Application by Highways England for TR010031: A1 Birtley to Coal House Improvement Scheme

The Examining Authority's Further Written Questions and requests for information (ExQ4)

Issued on 6 July 2020

Drawing Number	Originator	Volume	Revision
HE551462	WSP	6.3	P06

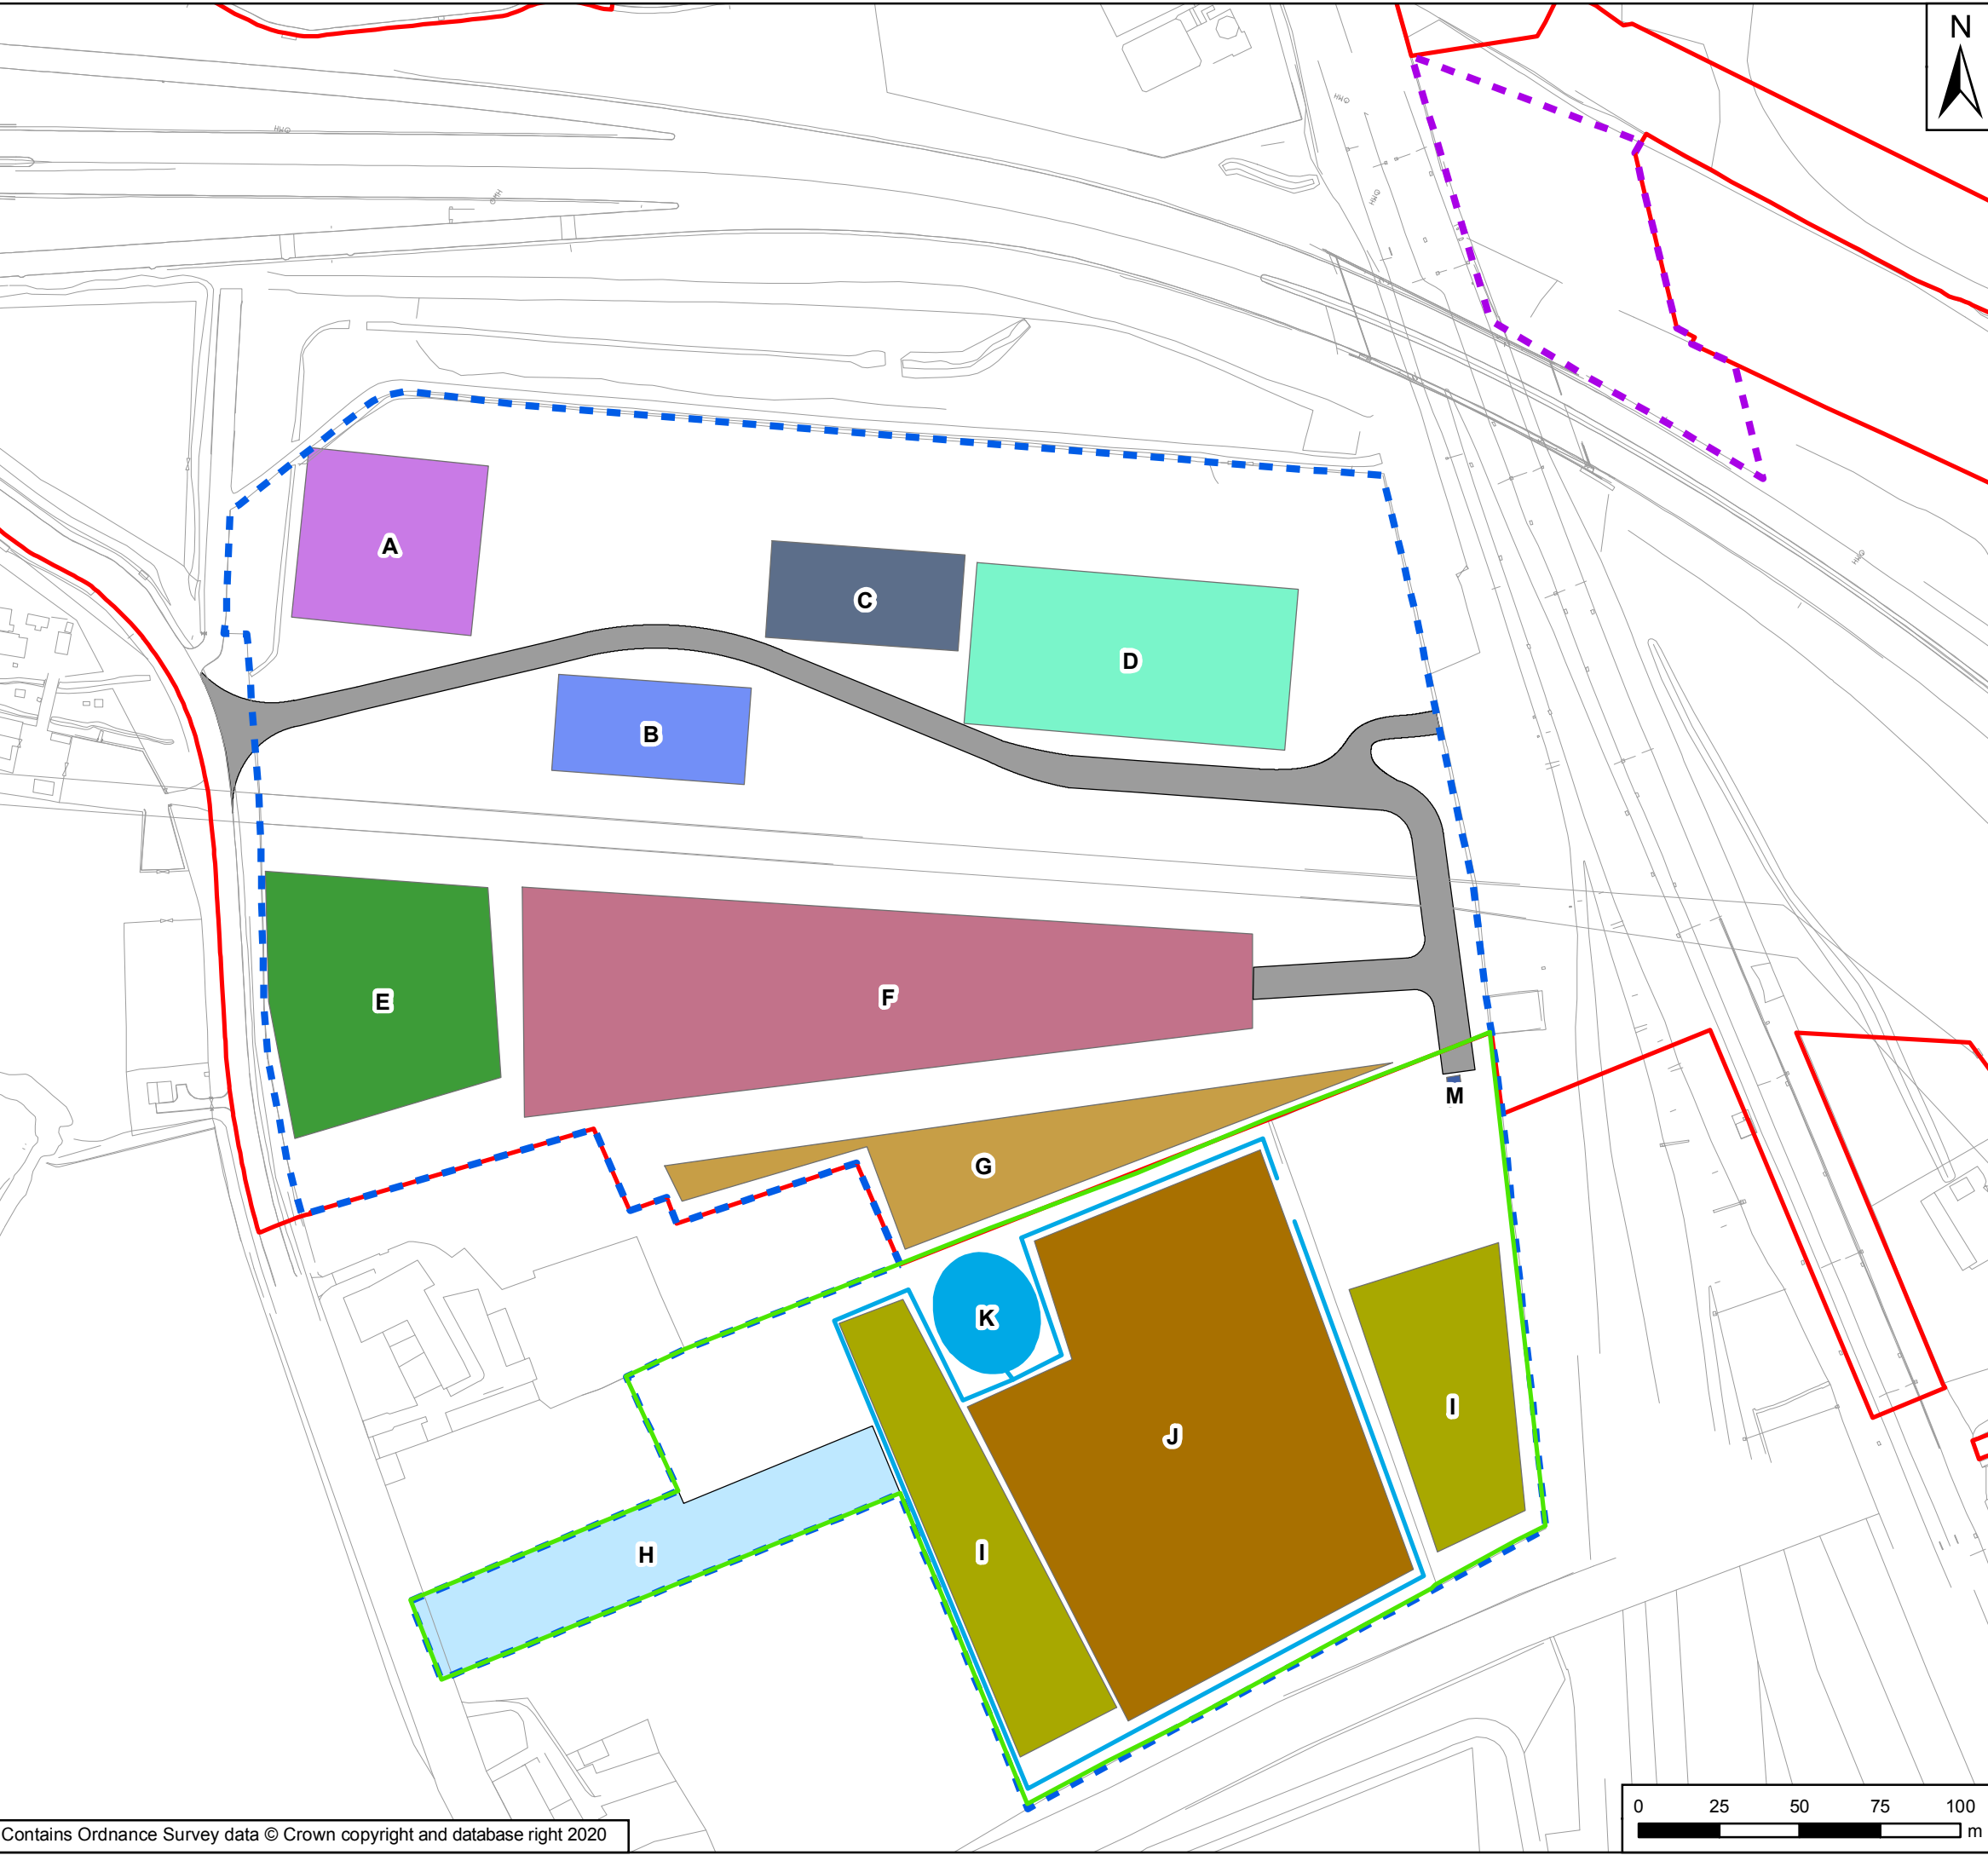
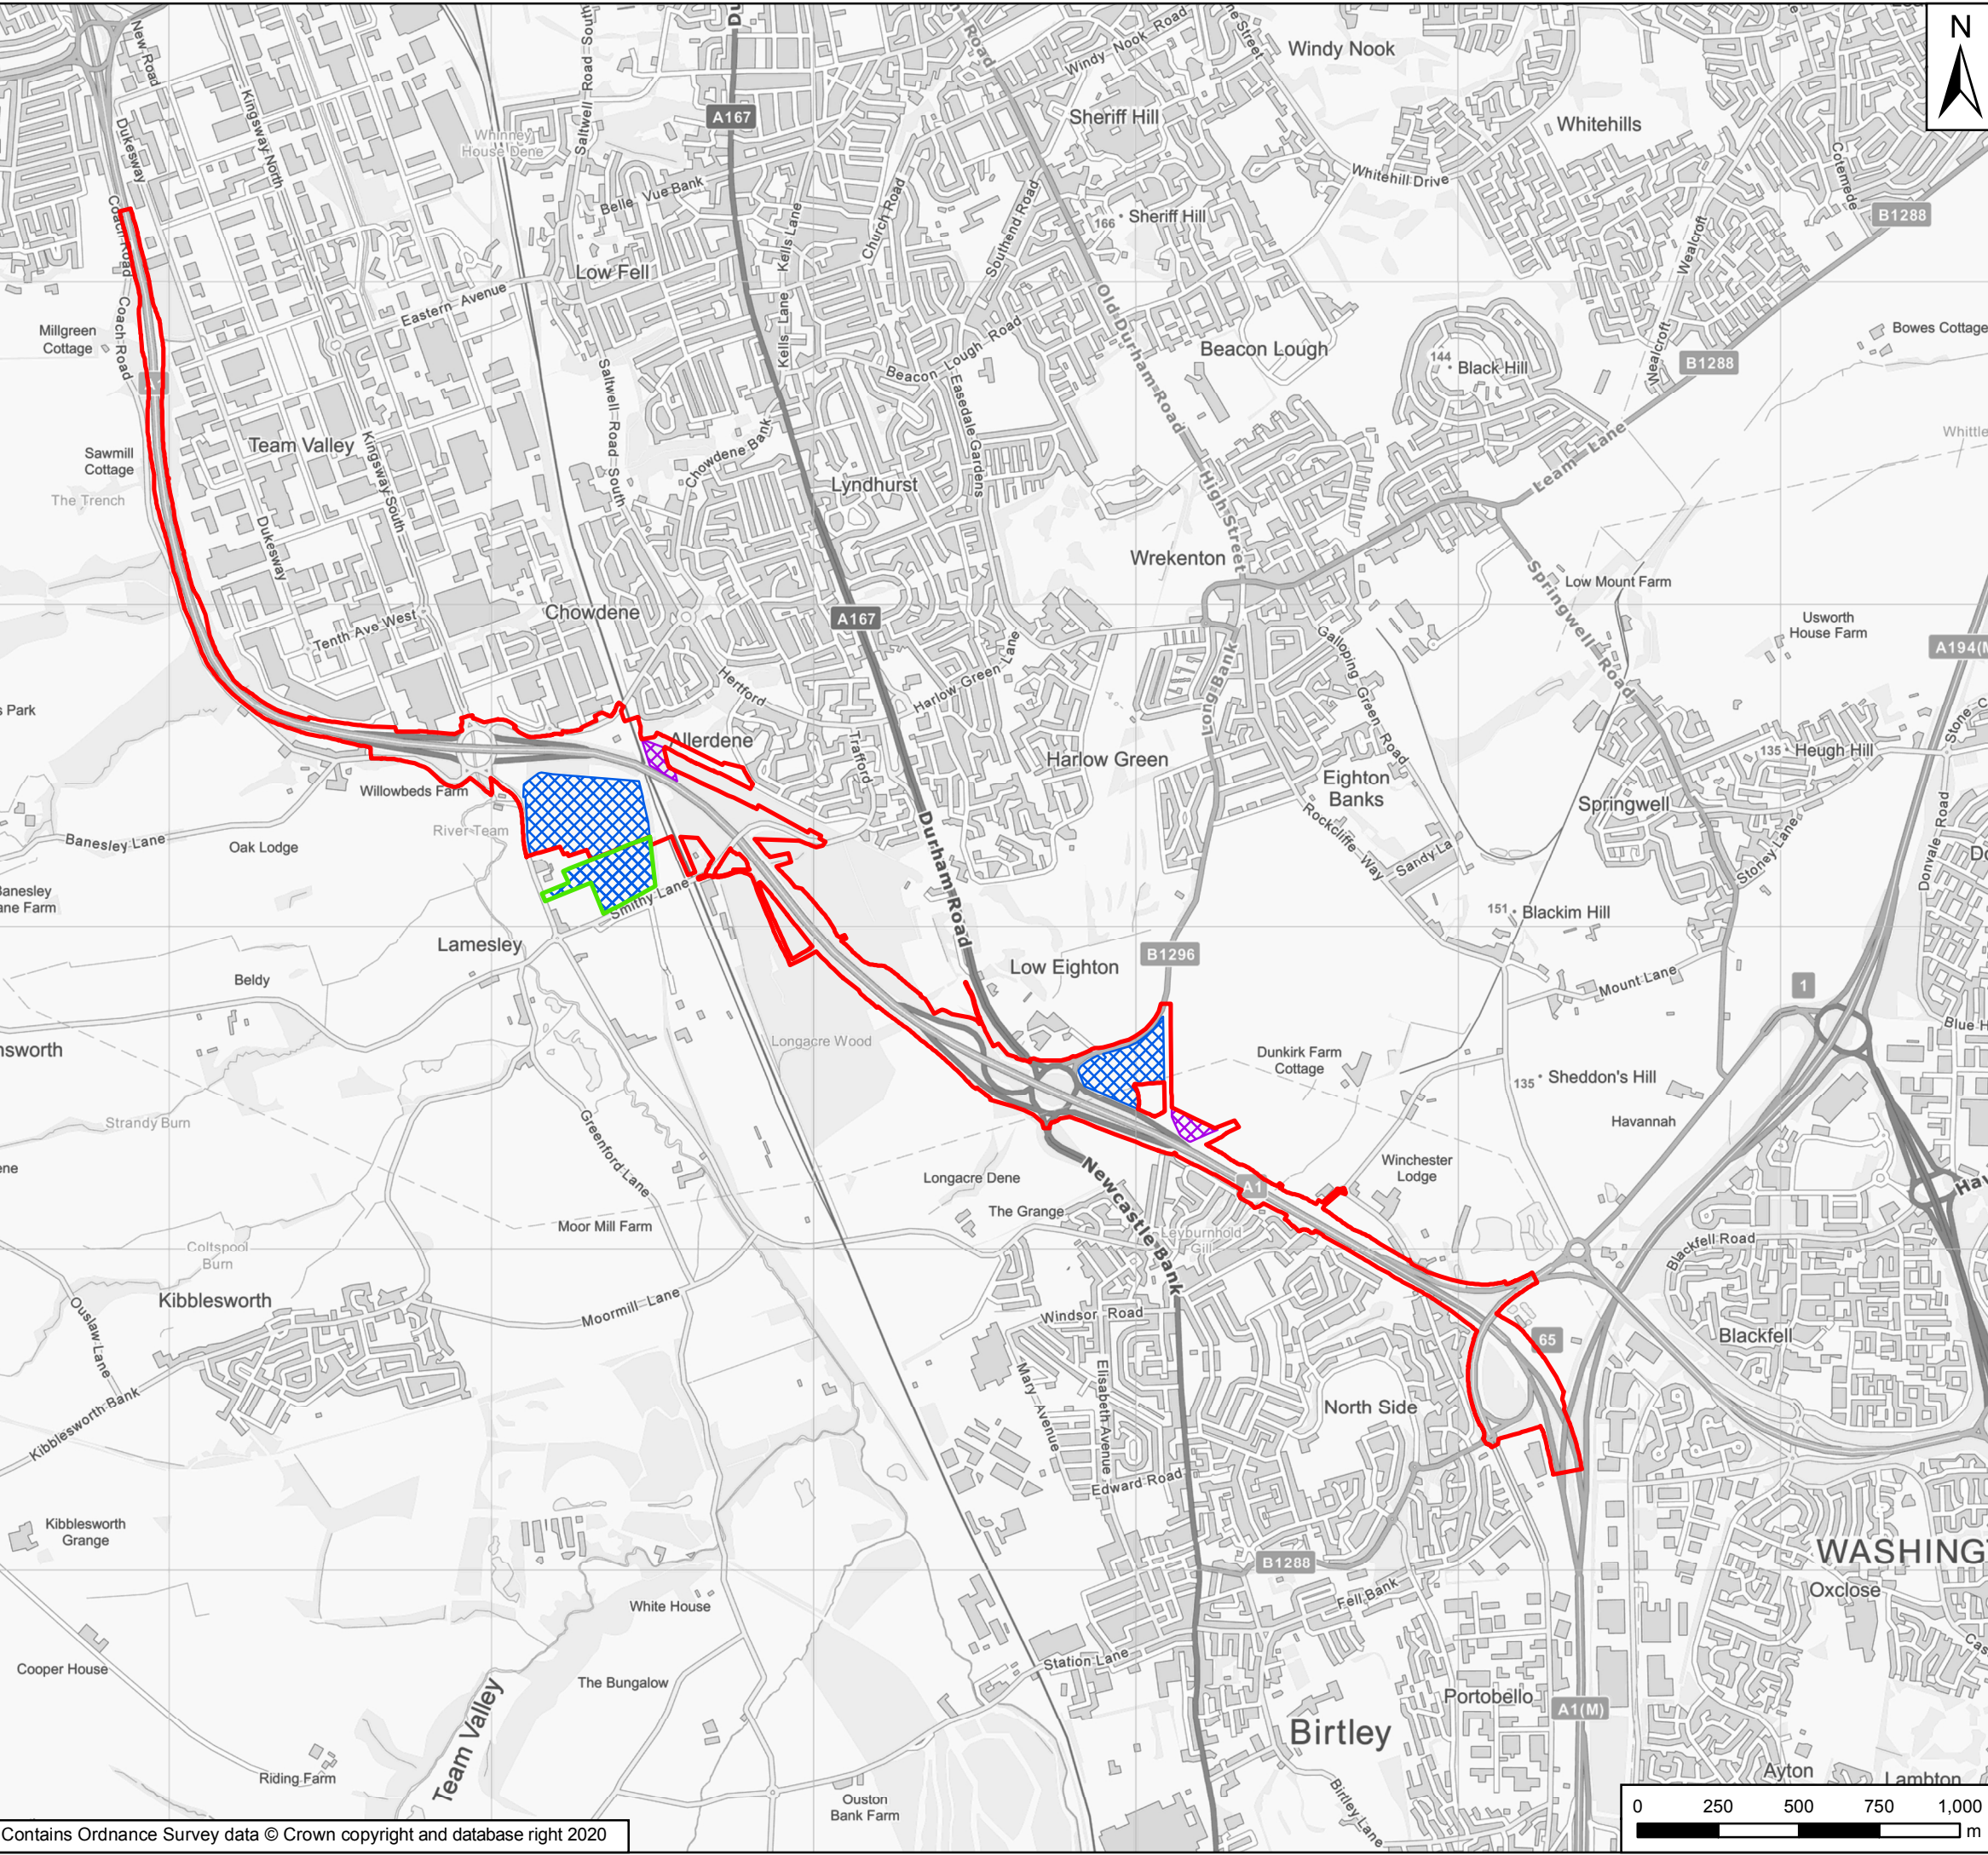
4.1 Compulsory acquisition		
4.1.1	Applicant	<p>Figure 1/Al Site Compound Plan Detailed View, Junction 67 (Additional Land) of Appendix A of the Construction Environmental Management Plan [REP8-007] shows what appears to be areas of spare (white) space with the northernmost part of the compound, with no designated use.</p> <p>Given the amount of space that appears not to be required for any designated use or purpose within the compound, how can the Secretary of State be satisfied that the amount of land proposed to be acquired is no more than is reasonably required?</p>
Please note that Question 4.0.3 above also concerns matters regarding compulsory acquisition.
